A585 Windy Harbour to Skippool Improvement Scheme

7.11 Environmental Statement Changes and Corrections Document

August 2019

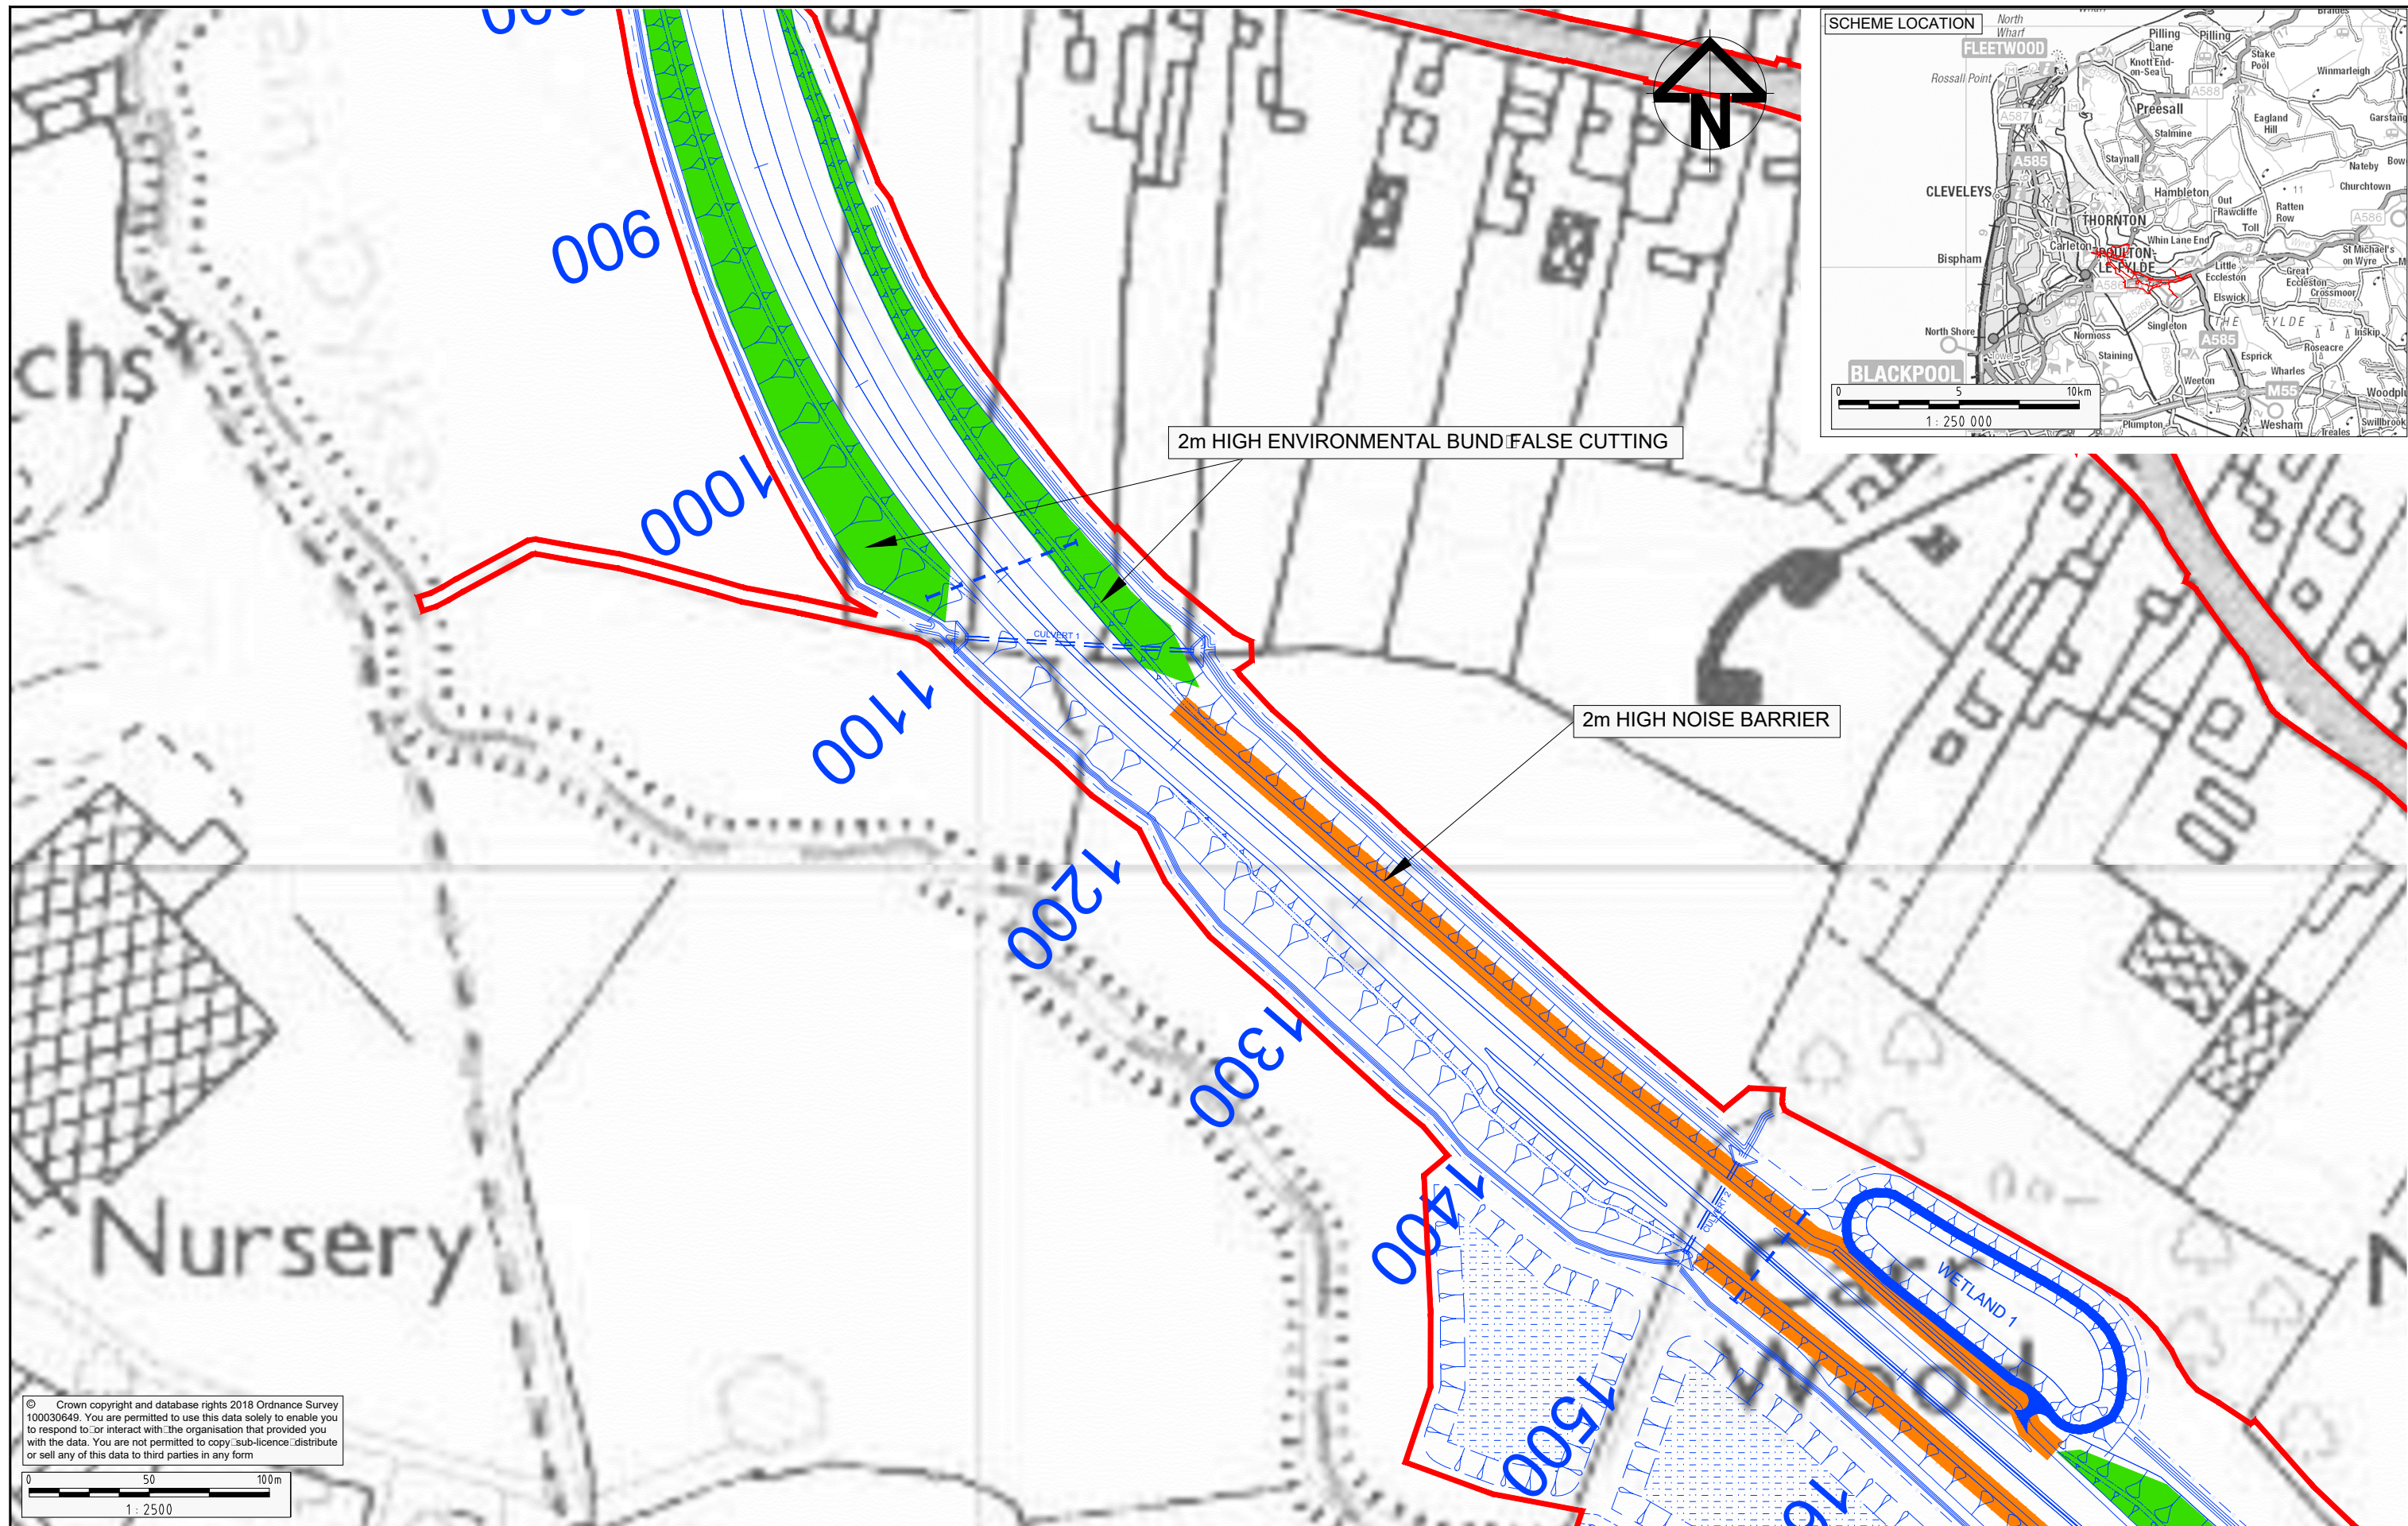
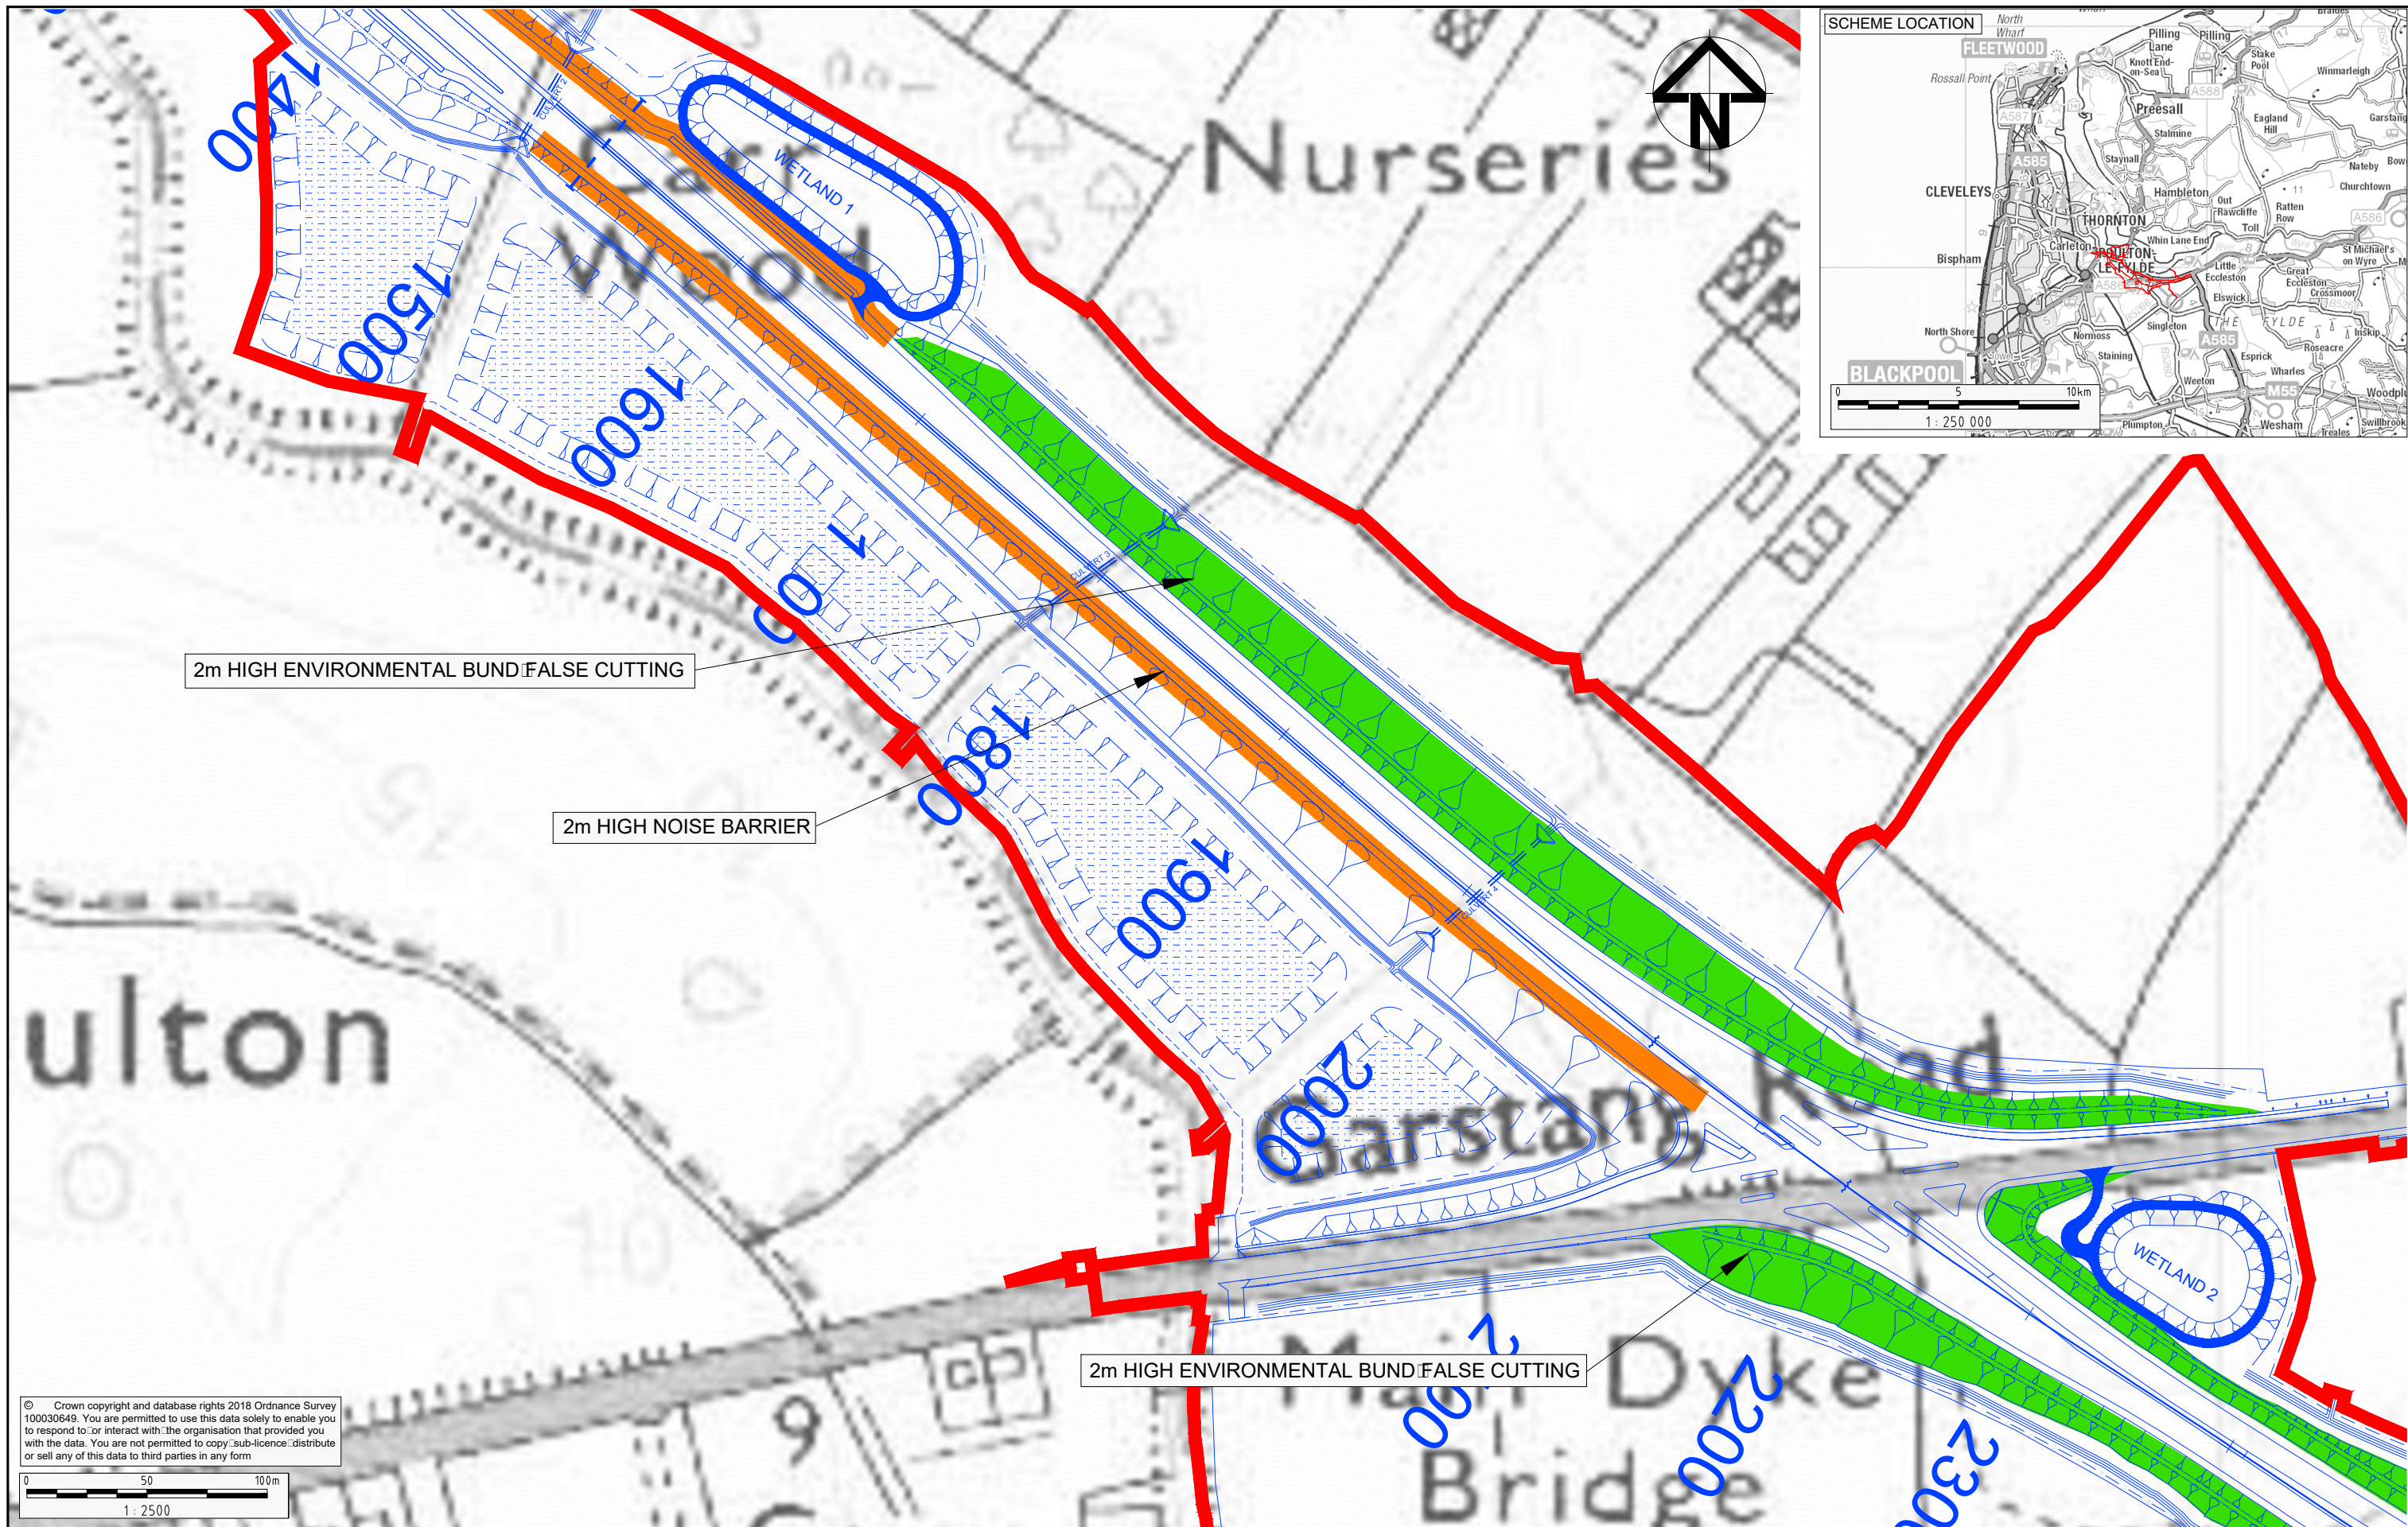
Document Reference Number	Document Name	Amendment Required	Reason
			TR010035/APP/7.10).
6.11	ES Chapter 11: Noise and Vibration	Update to Figure 11.4: Noise and Vibration – Noise Mitigation within the Study Area presented at Appendix D to show heights and locations of earth mounds and acoustic fencing at a larger scale.	Requested by the Inspector within the first round of written questions (document reference TR010035/APP/7.10).
